Arun District Council
Arun Civic Centre
Maltravers Road
Littlehampton
West Sussex BN17 5LF
Planning & Building Control General Enquiries
Tel: (01903) 737756 Fax: (01903) 730442
Dx: 57406 Littlehampton
Minicom: 01903 732765
e-mail: planning@arun.gov.uk
website: www.arun.gov.uk/planning

Application No: BR/244/20/PL
Site Address: The Beach Hotel, former Mud Club Waterloo Square Bognor Regis PO21 1SU
Description of works: Redevelopment into 11 No. 2 bed apartments & 2 No. commercial units (A1 Retail or A3 Restaurant/Cafe) (resubmission following BR/282/19/PL). This application affects the character & appearance of The Steyne, Bognor Regis Conservation Area & may affect the setting of listed buildings. This site is in CIL Zone 4 (Zero Rated) as flats & other development.

Thank you for your internet representation made on 17th November 2020 which has been recorded as no objection with the comments as follows:

Drawing Number / Revision:
18.103.201

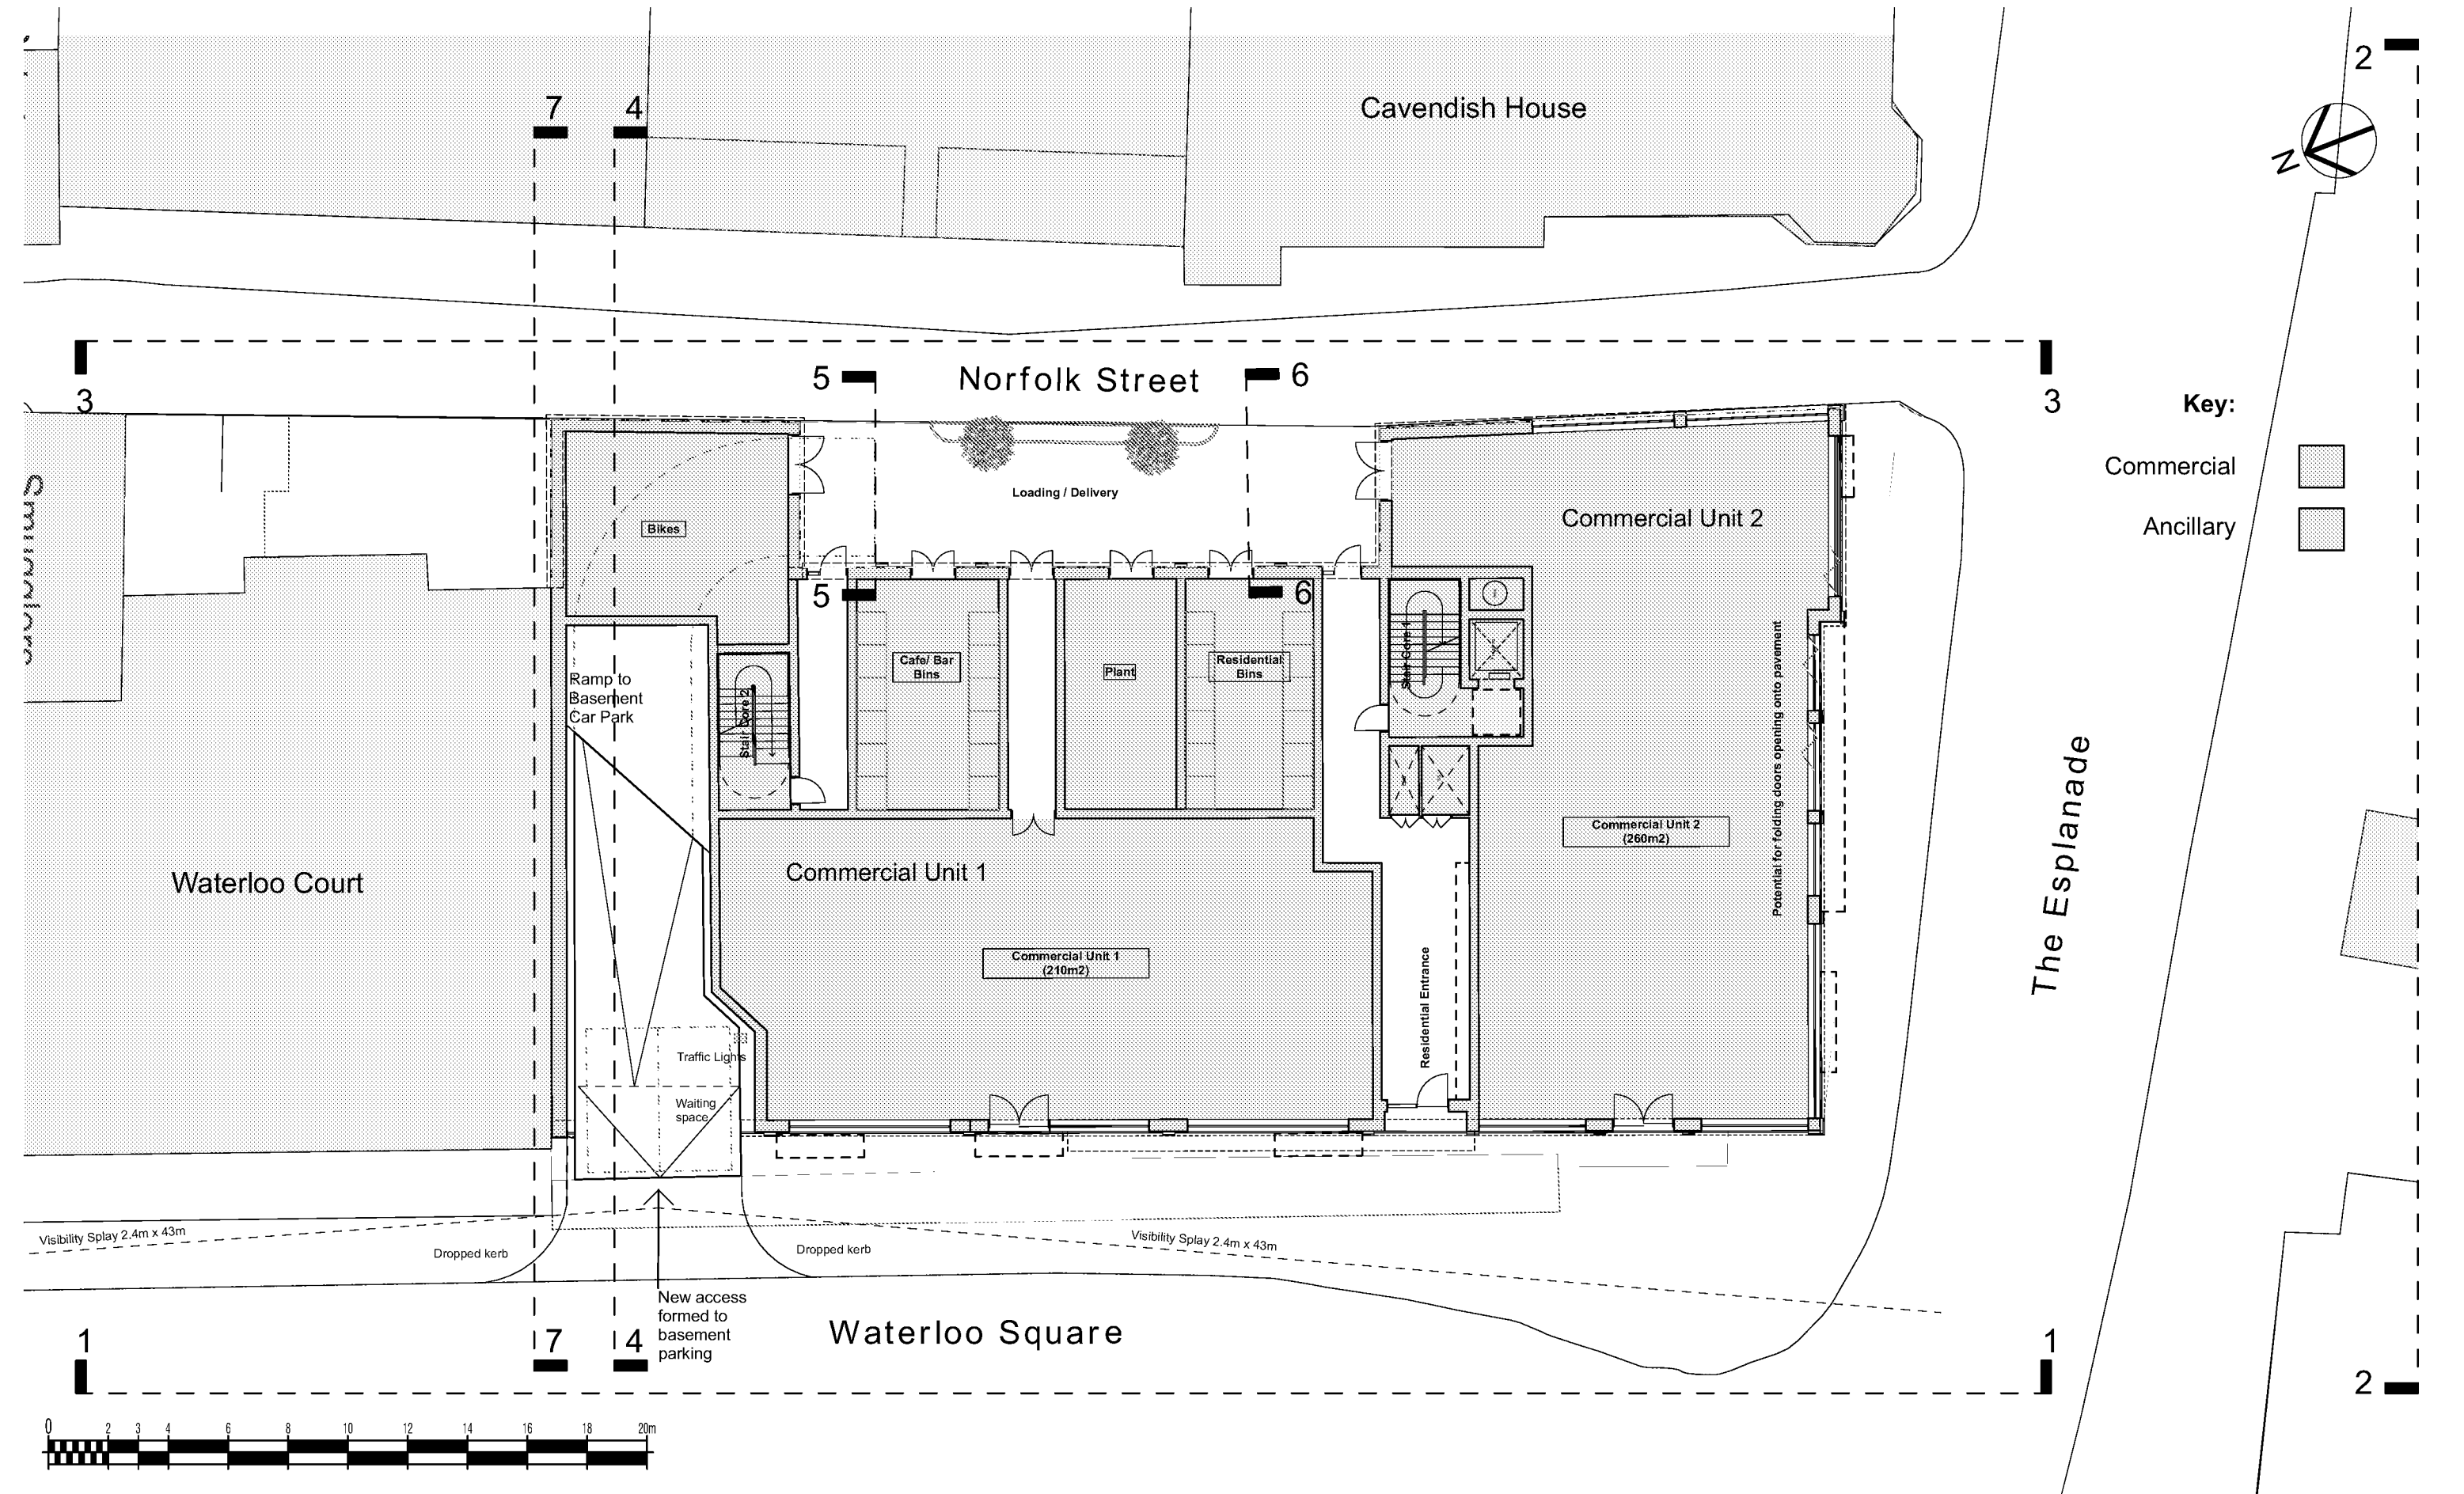
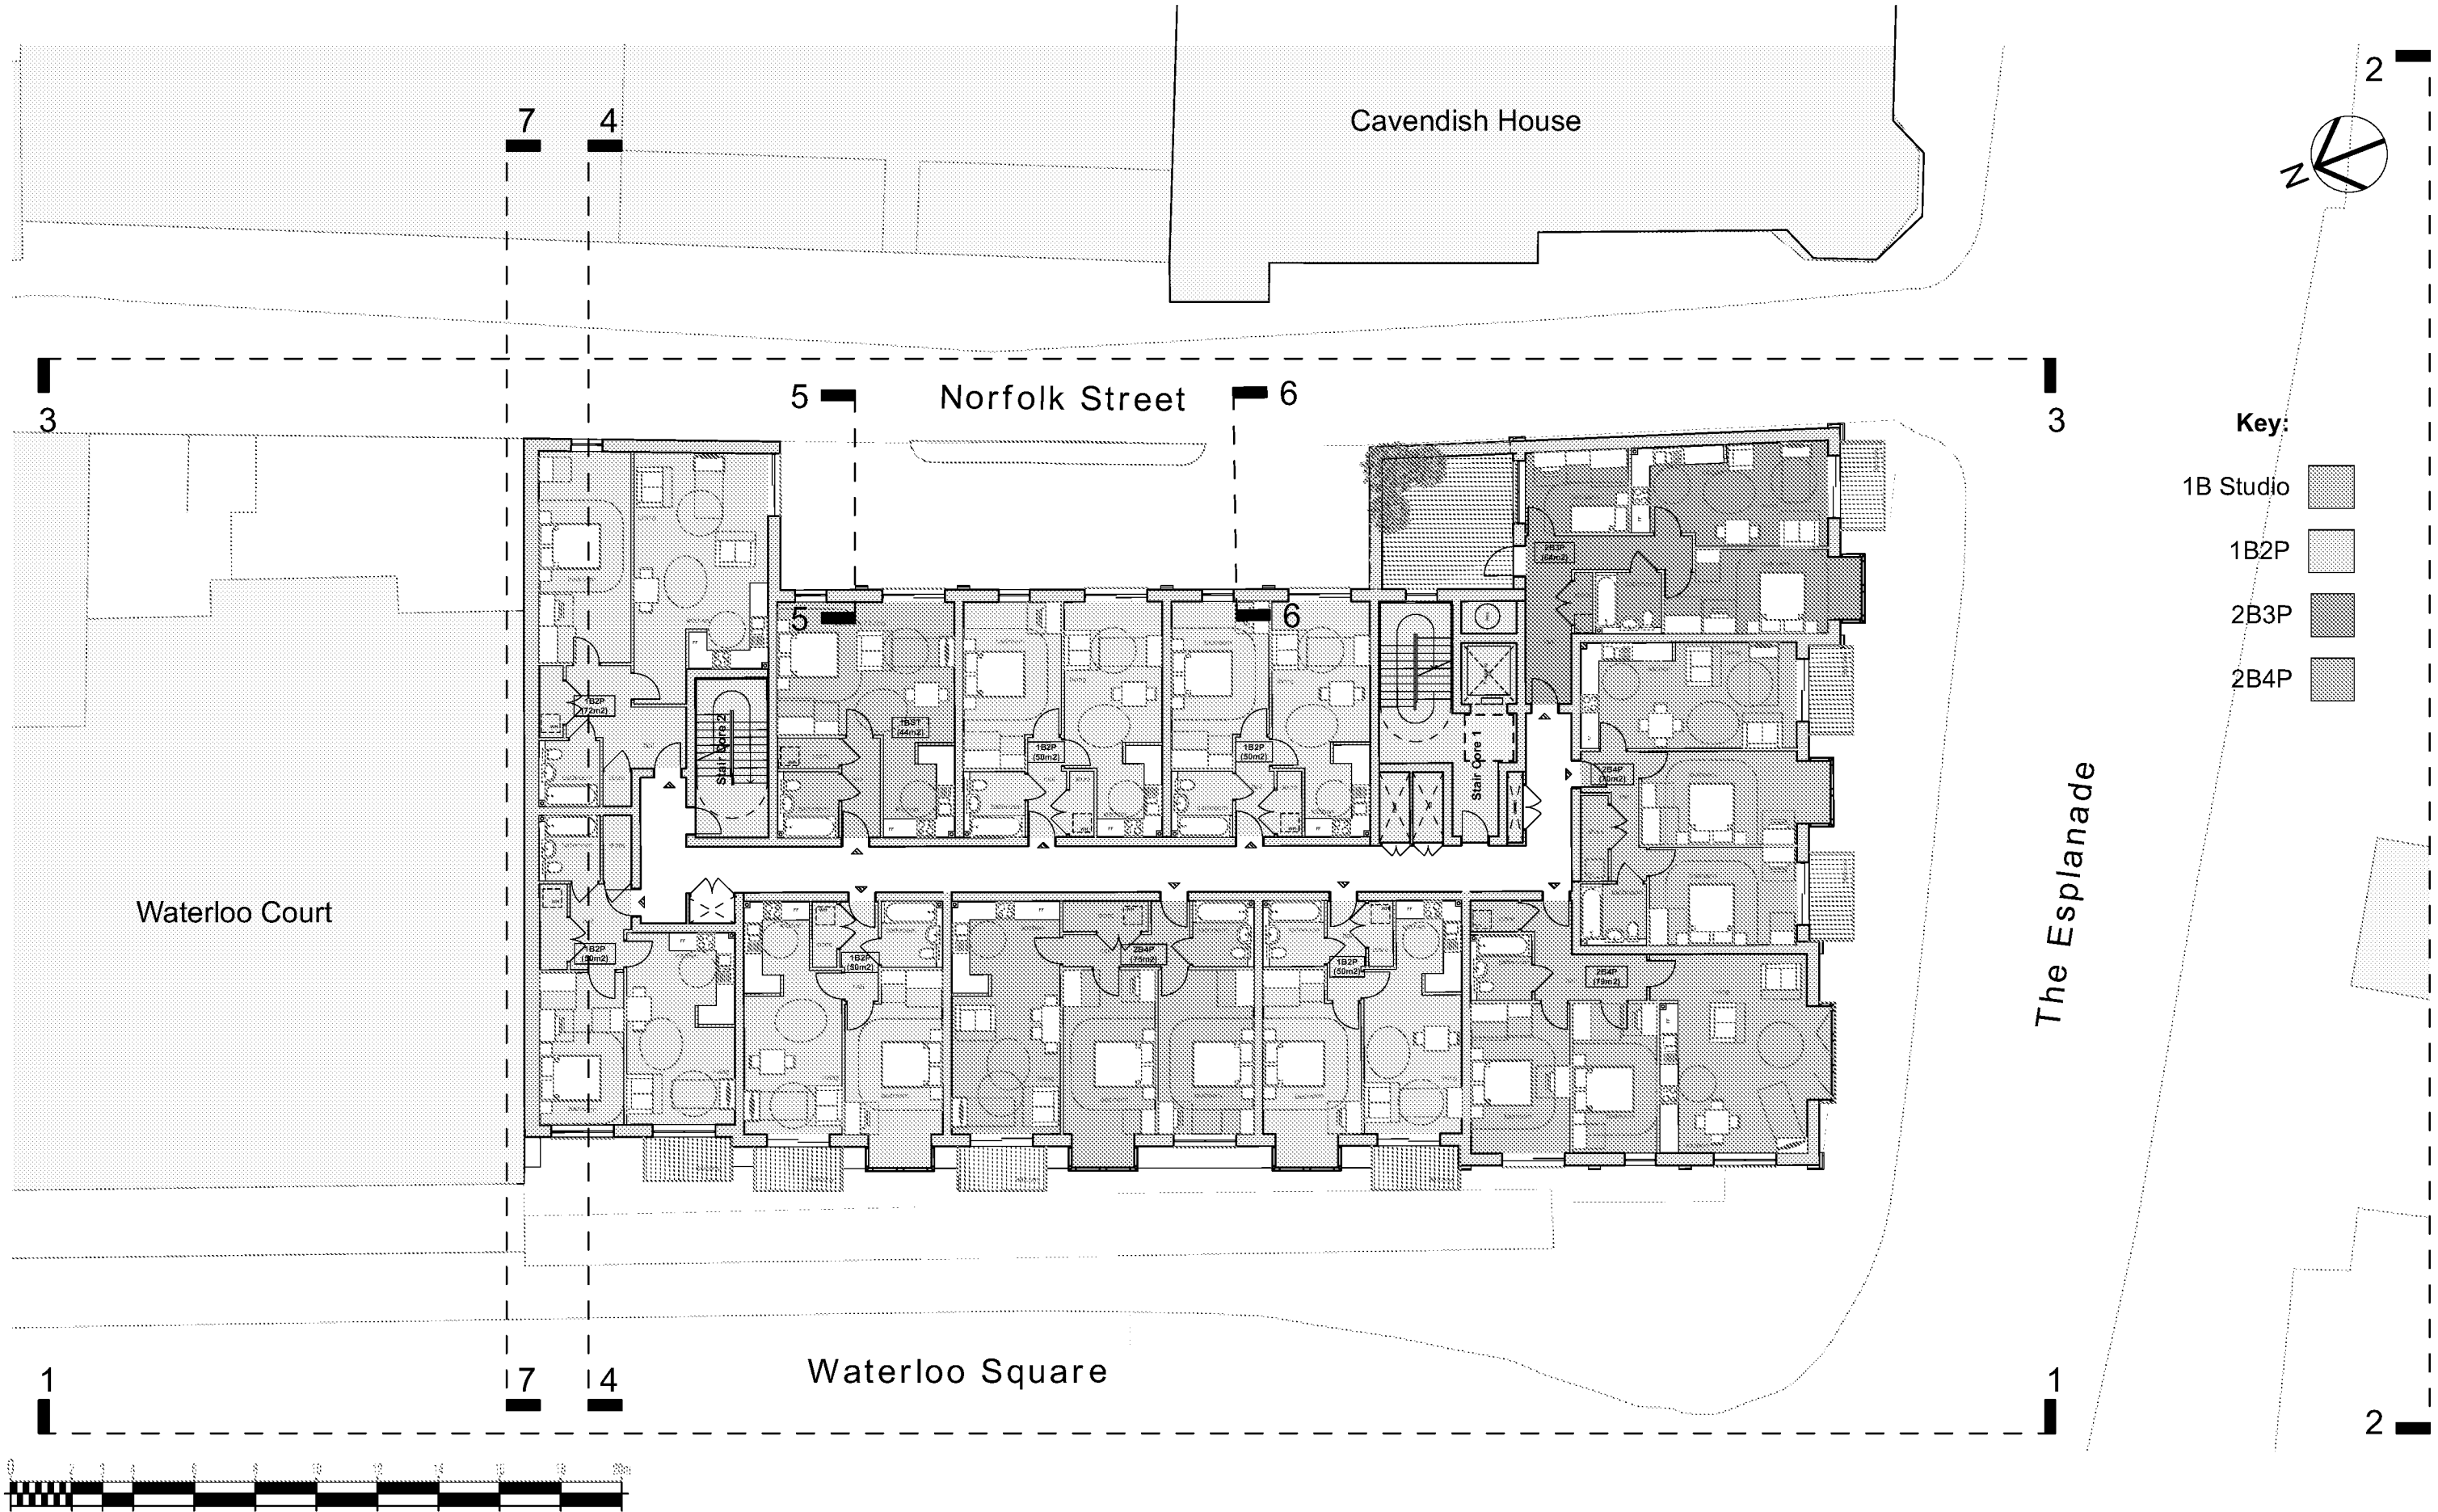
- The height of the proposed building, being at least 1.5 storeys higher than adjacent roof lines along The Esplanade and substantially higher still than those of Waterloo Square, is out of keeping with the local street scene and therefore does not respect the character and identity of the area nor does it integrate with the scale and proportion of surrounding buildings. Should the application be approved it would set a new precedent for building heights in the Old Town area which would not accord with the constraints of the Conservation Area or the principles outlined in the Bognor Regis Masterplan.
